Technical Note

Project No: ITB13091
Project Title: Land South of the A259, Angmering
Title: Stage 1 Road Safety Audit – GG119 Response Format
Ref: DS/ITB16357-013
Date: 10 March 2022

Report Title:	Stage 1 Road Safety Audit
Date:	February 2022
Document Reference and Revision:	RSA-21-188
Prepared by:	Fenley Road Safety Limited
On behalf of:	West Sussex County Council

Preliminary Design Check – A259 Littlehampton Road / Site Access Priority Junction Left-in / Left-out (Drawing No ITB16357-GA-004 Rev F)

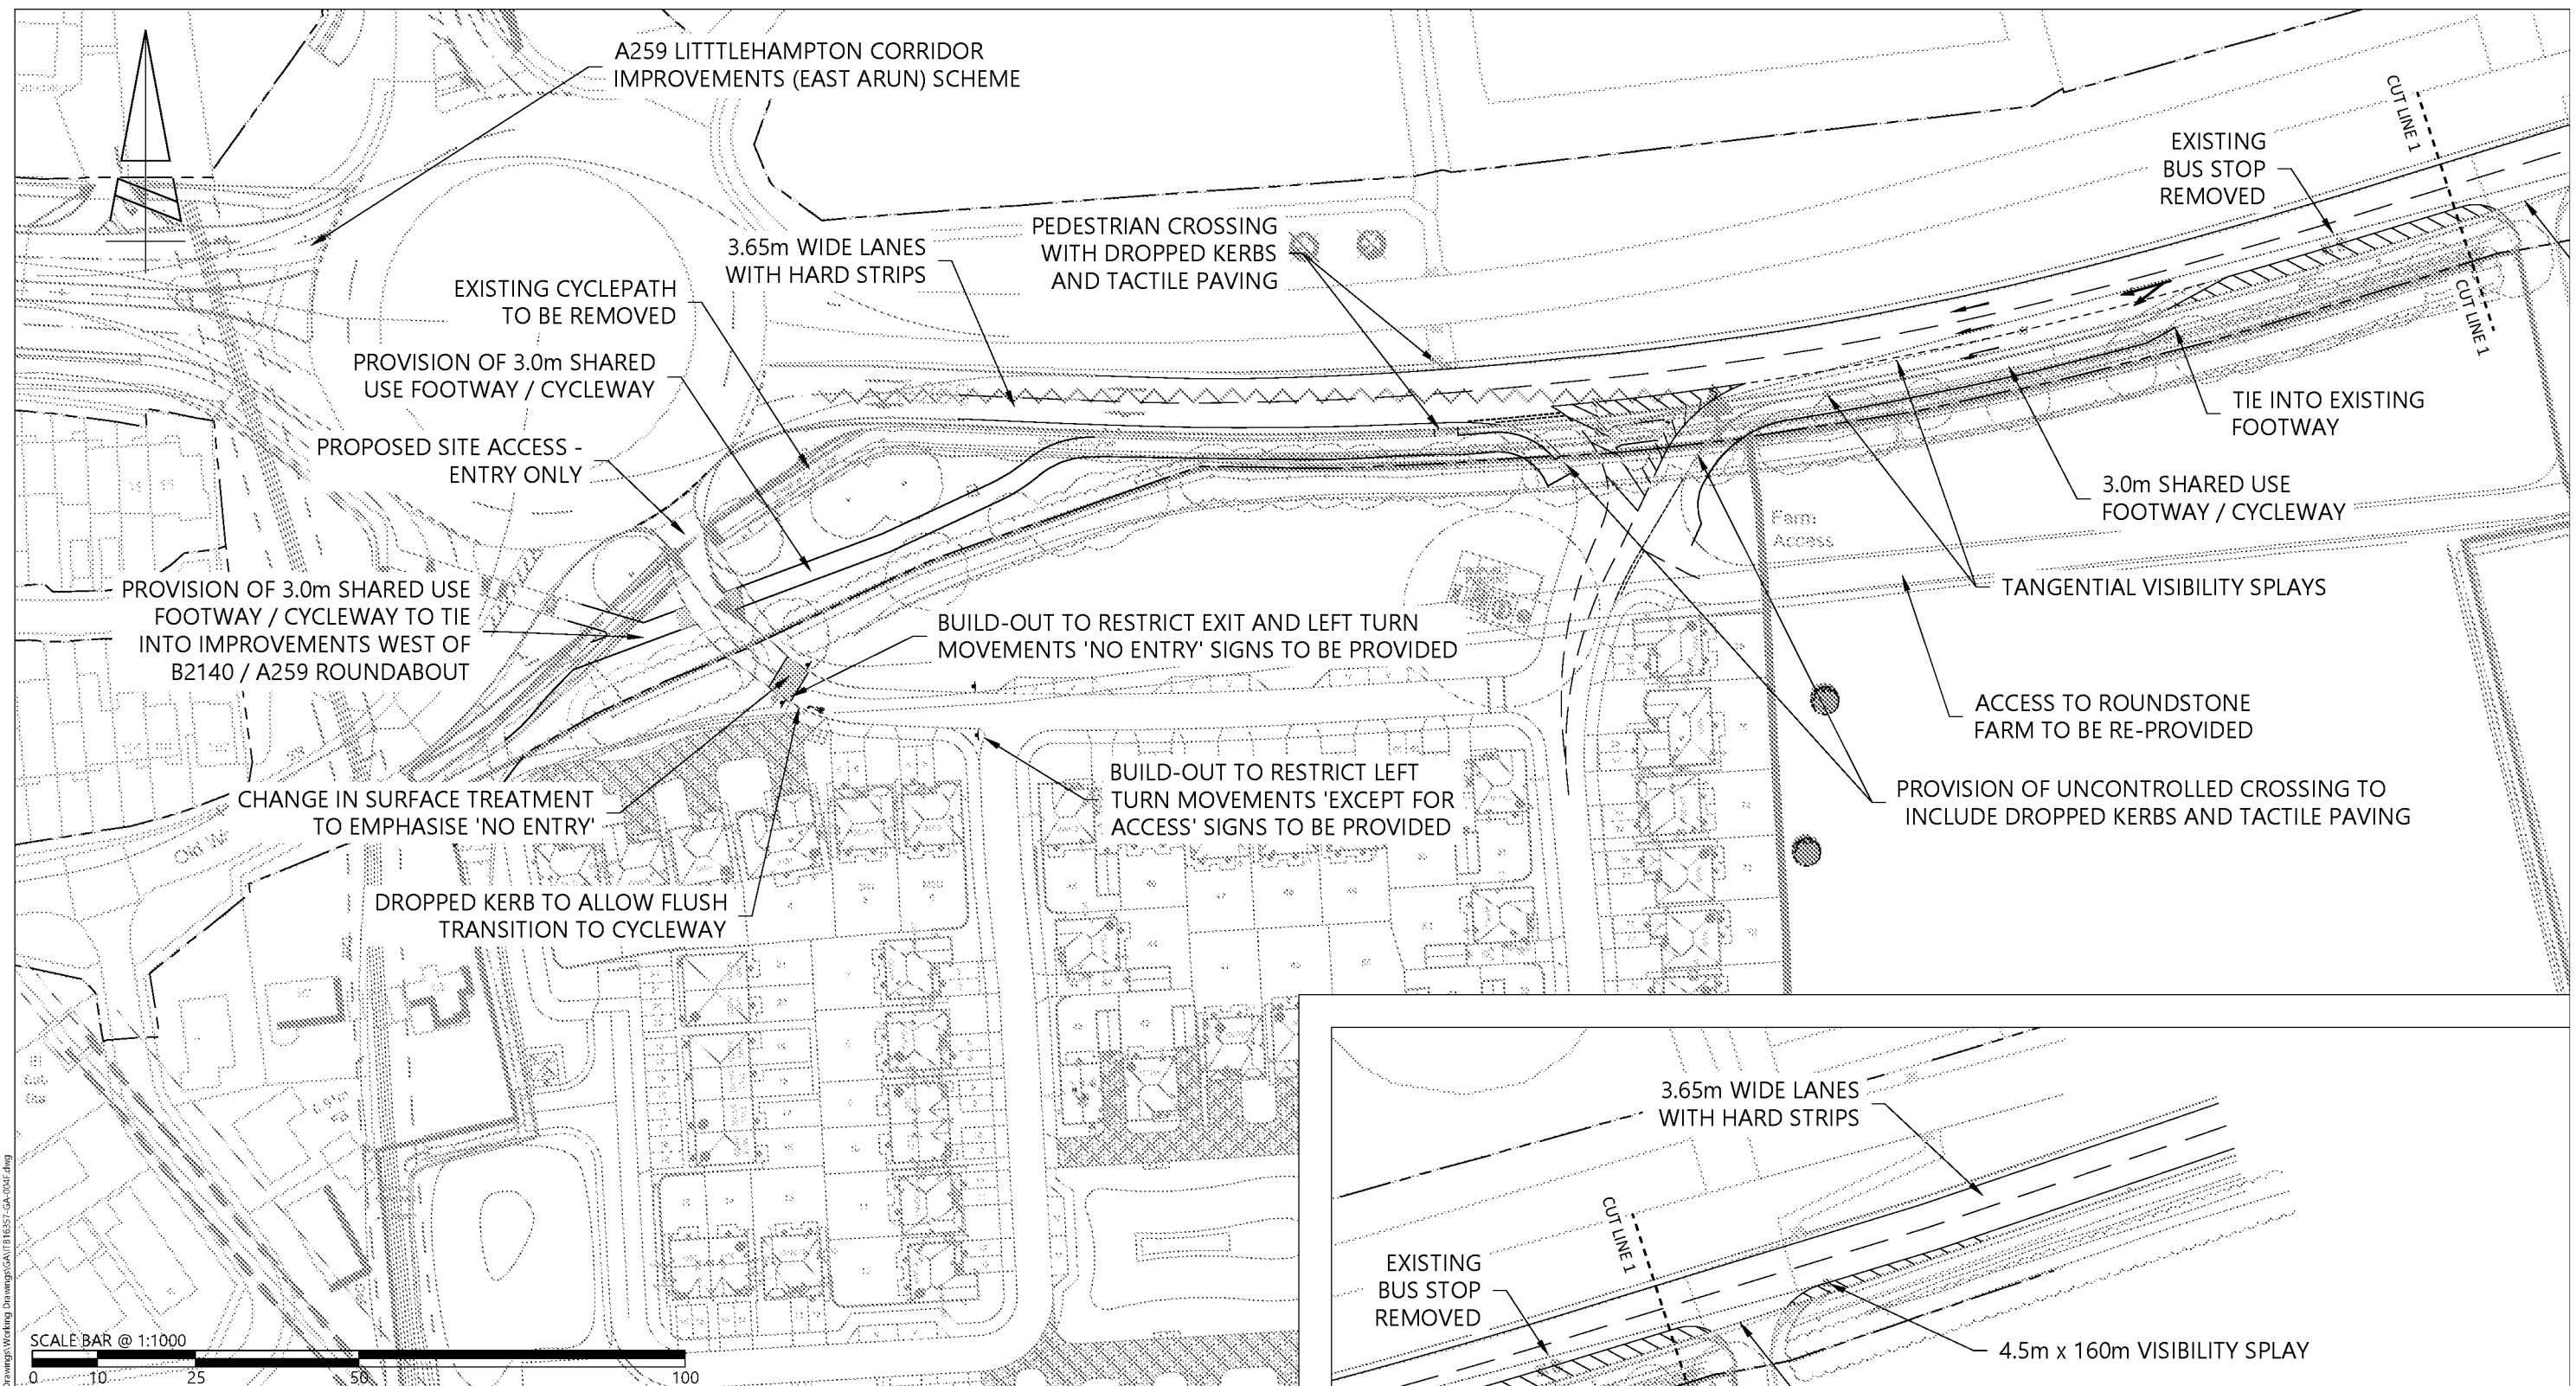
3.1: An inadequate diverge lane is provided.	It is recommended that the diverge lane is increased in accordance with Table 5.22 of CD123.	Agreed – diverge lane has been slightly lengthened to provide 80m between from the location at which it has been measured by the Auditor. This is incorporated into amended drawing ITB16357-GA-004

3.2: A small entry radius is provided	It is recommended that the entry radius is increased to 20 metres in accordance with paragraph 5.6.5 of CD123.	Agreed – radius has been increased to 20m and incorporated into drawing ITB16357-GA-004 Rev F.

RSA Problem	RSA Recommendation	Design Organisation Response	Overseeing Organisation Response	Agreed RSA Action
3.3: Spacing of existing field entrance from A259 westbound entry is minimal and a small corner radius is provided.	It is recommended that the exit radius is increased with reference to the minimum entry radius in accordance with paragraph 3.29 of CD116.	Agreed – a 20m radius has been introduced and the access road realigned accordingly. The changes are incorporated into drawing ITB16357-GA-004 Rev F.		
3.4: Traffic stopping to allow pedestrian and cyclists across the field entrance will block back onto the circulatory.	It is recommended that the uncontrolled crossing is relocated further from the circulatory.	Agreed – the crossing has been set back to the rear of the TPO trees and the amendments are incorporated into Drawing ITB16357-GA-004 Rev F.

RSA Problem	RSA Recommendation	Design Organisation Response	Overseeing Organisation Response	Agreed RSA Action
4.2: Pedestrians and cyclists are likely to wait within the offside margin which forms part of the carriageway.	It is recommended that the tactile paving is relocated appropriately, and depth is increased to 1200mm.	Agreed – the paving has been relocated and the depth increased, as shown in drawing 004 Rev F.

4.3: Pedestrians and cyclists may not become aware of the eastbound carriageway.	It is recommended that tactile paving is provided at the existing crossing points.	Agreed – while an existing crossing arrangement, tactile paving has been incorporated into drawing 004 Rev F.
